PLANNING DEPARTMENT – Development Review Services

April 1, 2015

RE: **Winrock Town Center**
Drainage Master Plan (DMP)
Engineer's Stamp Date 2-5-2015 (File: J19D058)

Storm Sewer Profile

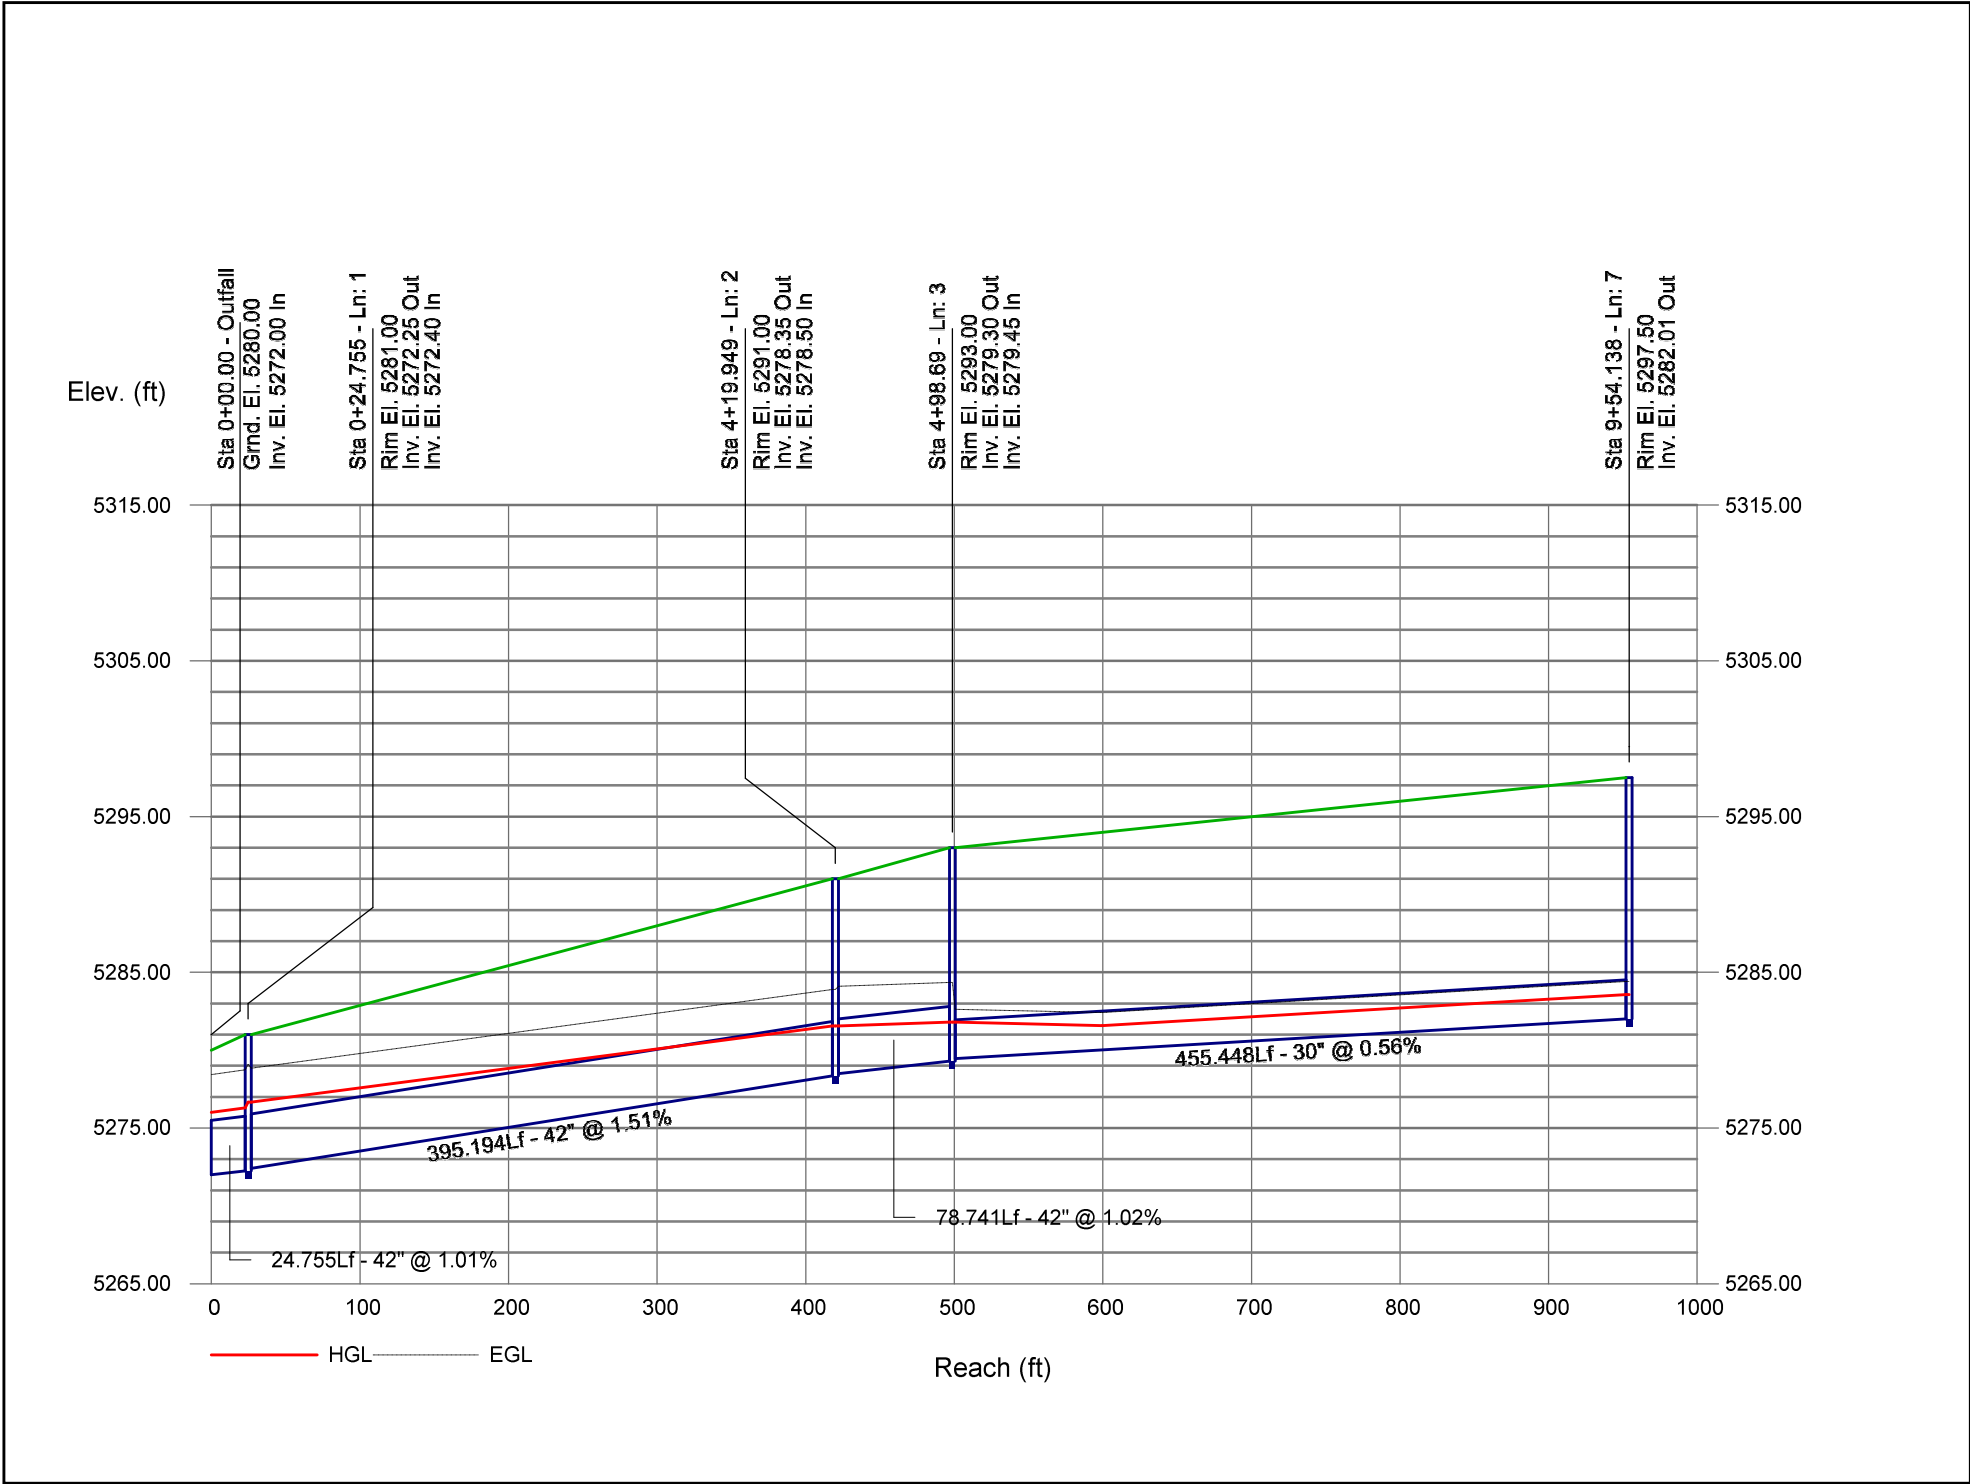
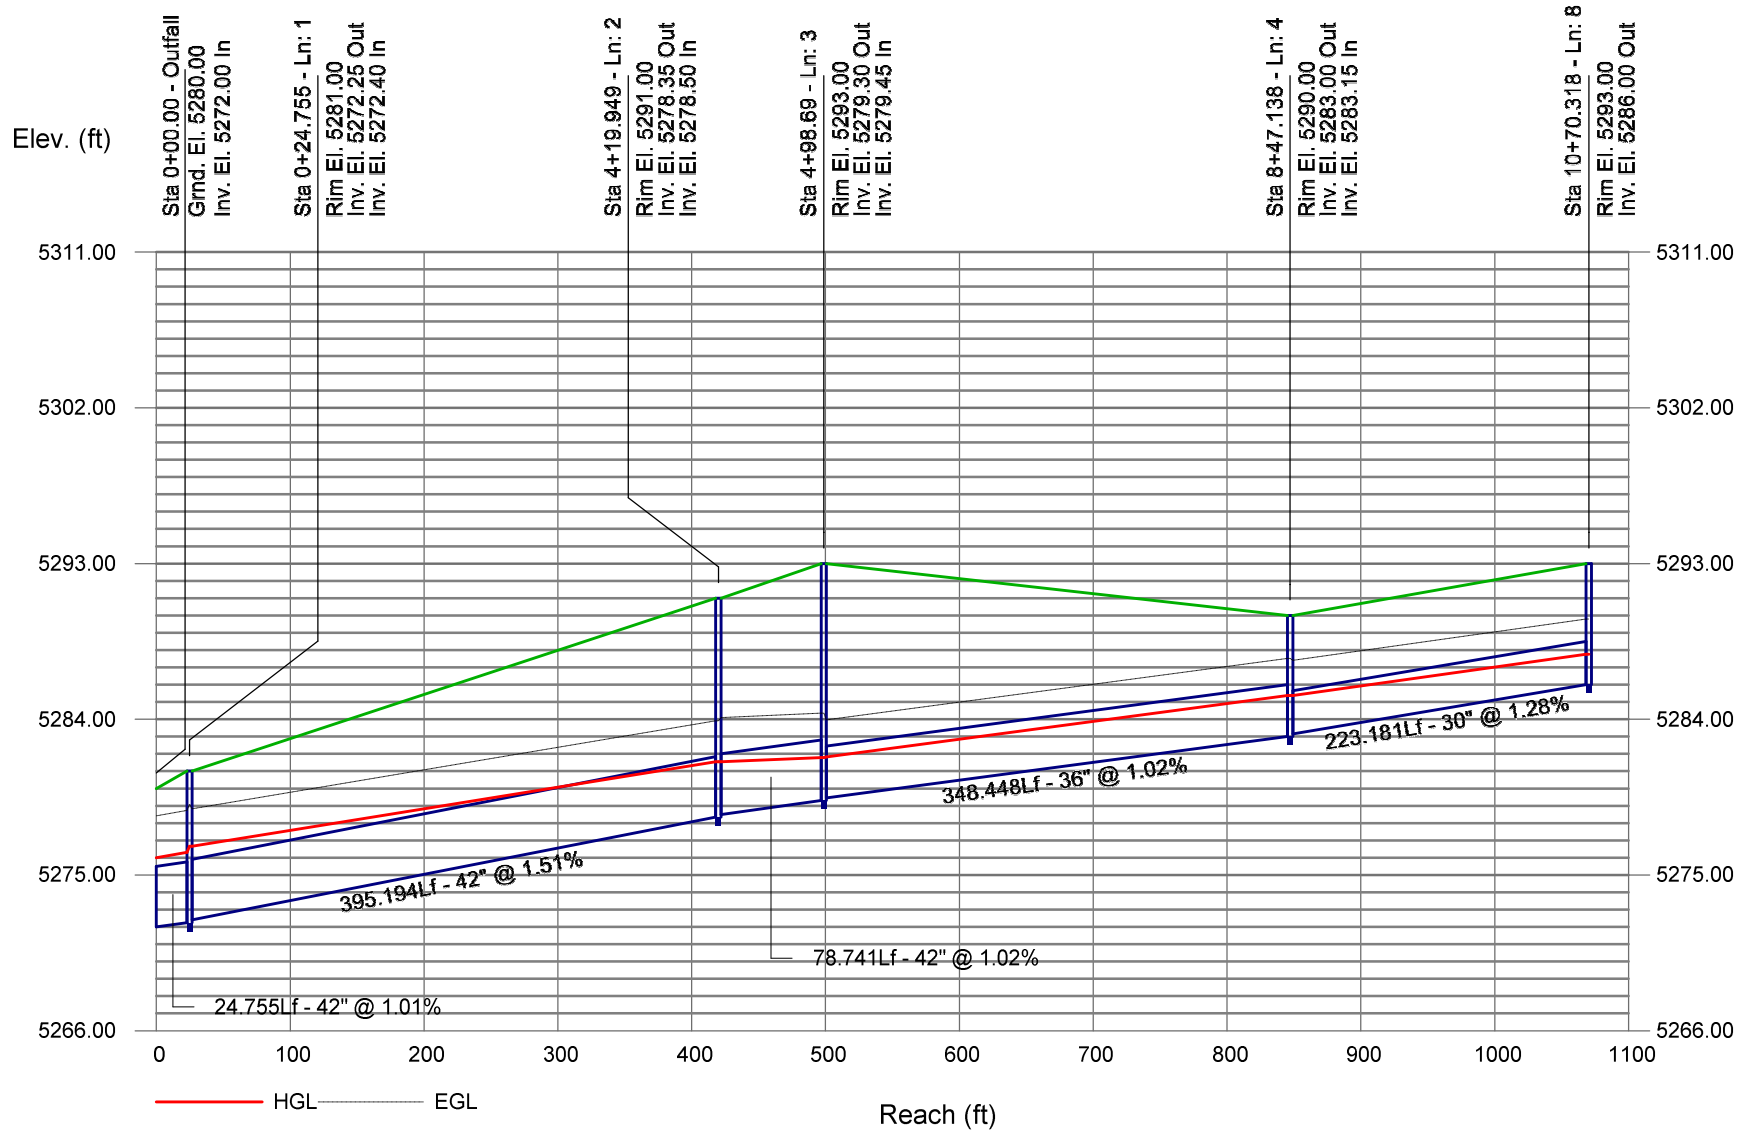
- e. Basin 400 discharges via surface flow to inlets on the ramp. Show inlets on plan and note as existing inlets. Show flow arrow to show that B400 does not discharge to the SD within its basin but is intended to maintain existing discharge.

- f. Show on the plan the size of Outfall #3 (discharge point outside of Basin 400)
- g. Huitt-Zollars Plan is utilizing existing SD in B400 that is not shown on DMP, and removing a SD that is shown in that same basin.

WINROCK TOWN CENTER BASIN 500

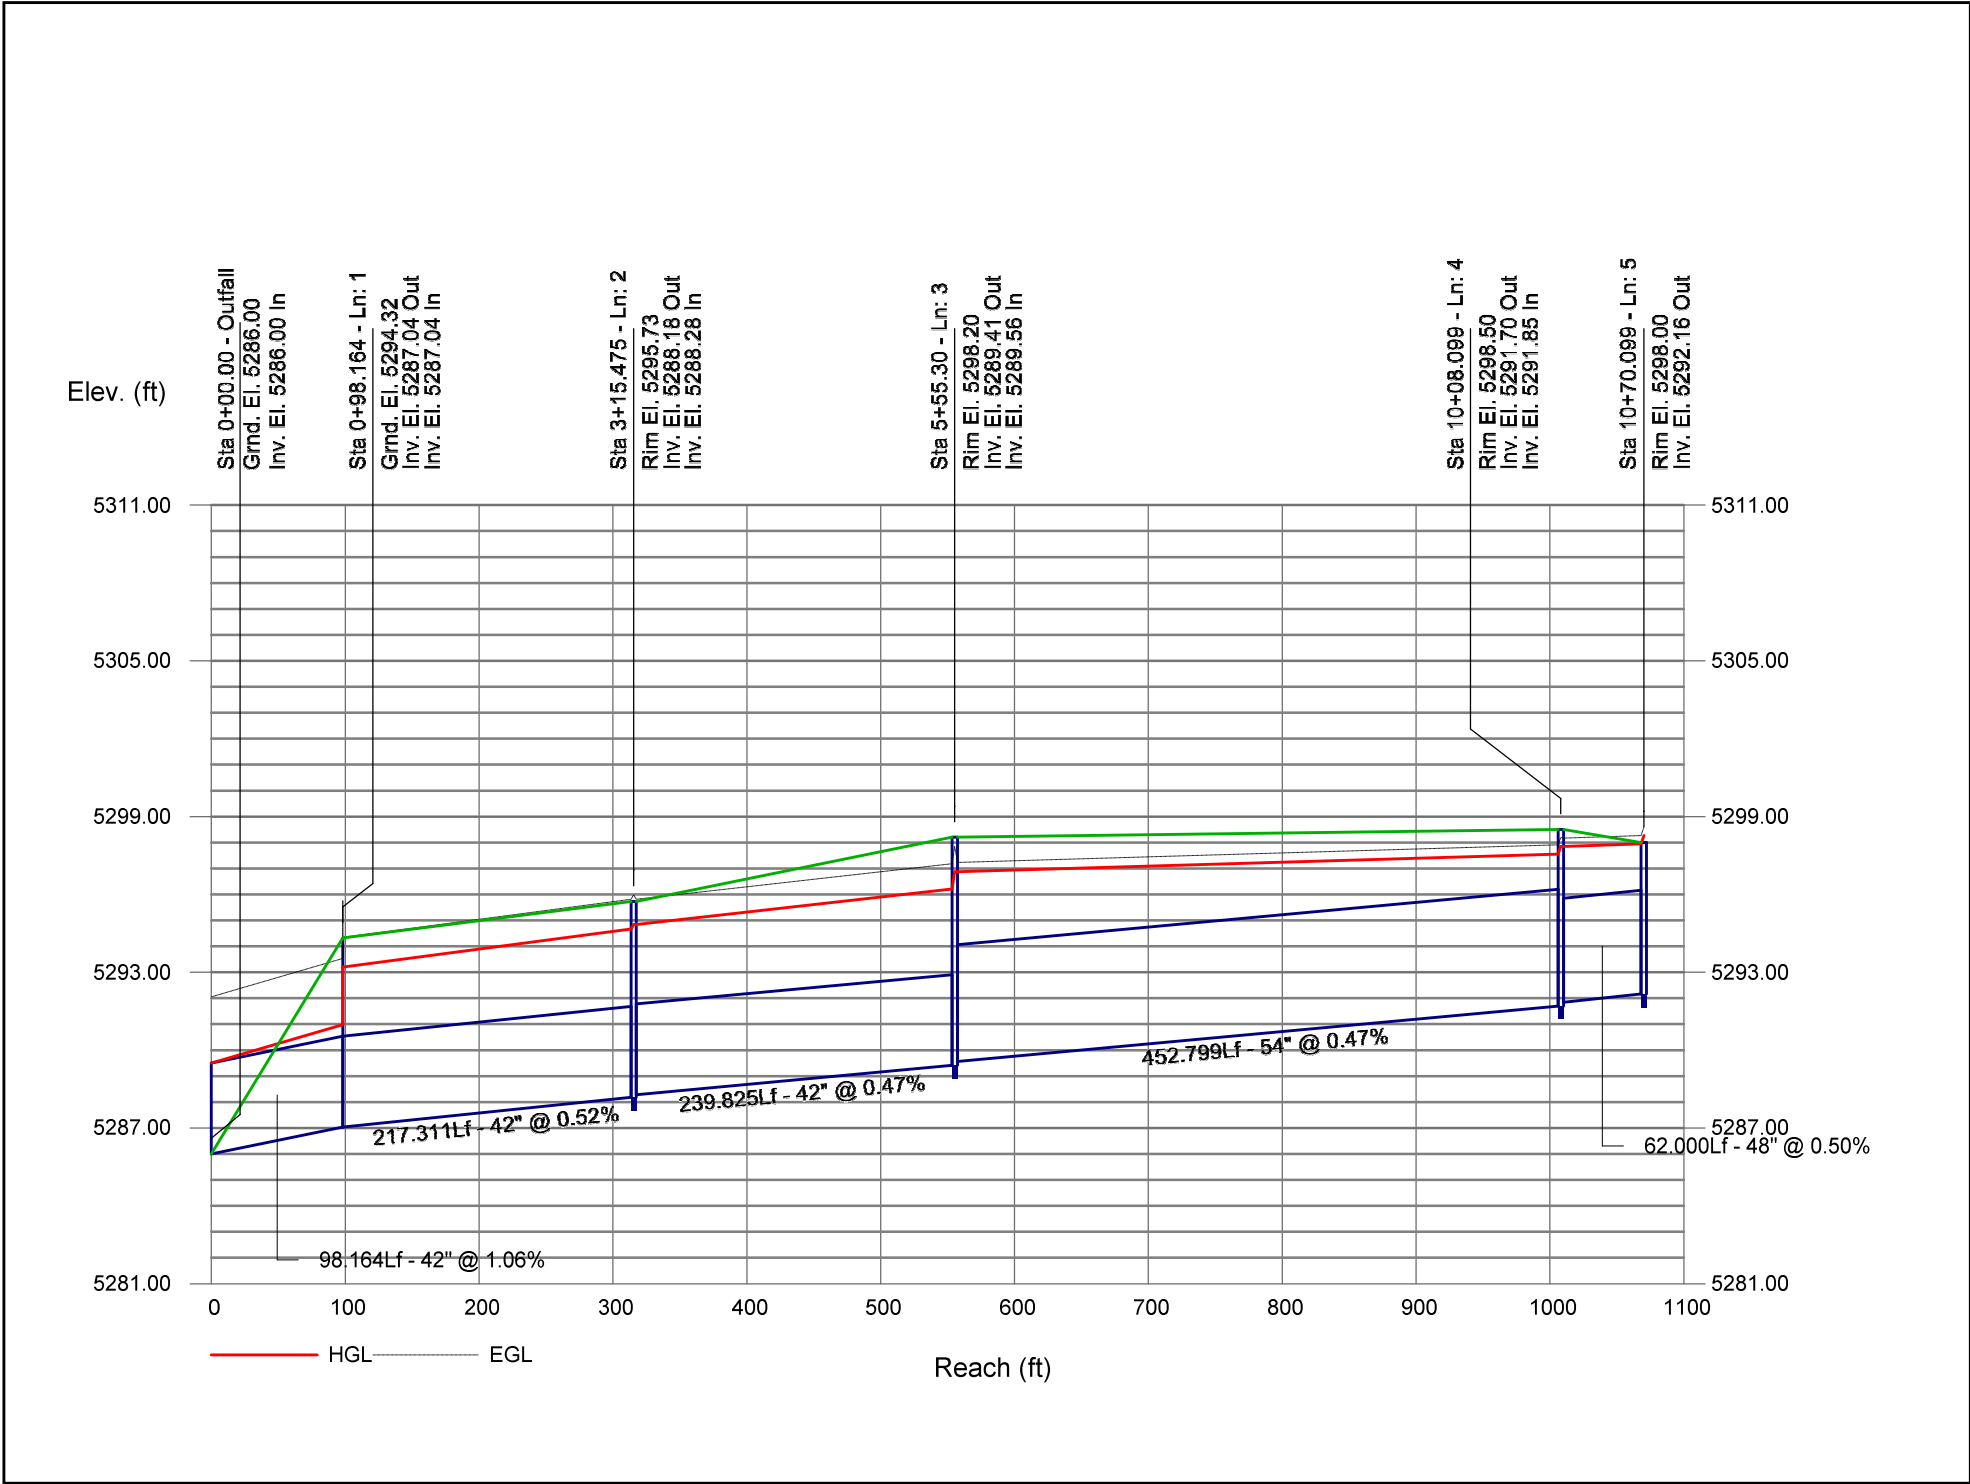
1. It is unclear what the limits of each Tract are. Please submit the proposed future plat.
2. Combine Basins 510 and 520.
3. In Appendix B, page 1, change labels to Undeveloped discharge and Proposed Discharge
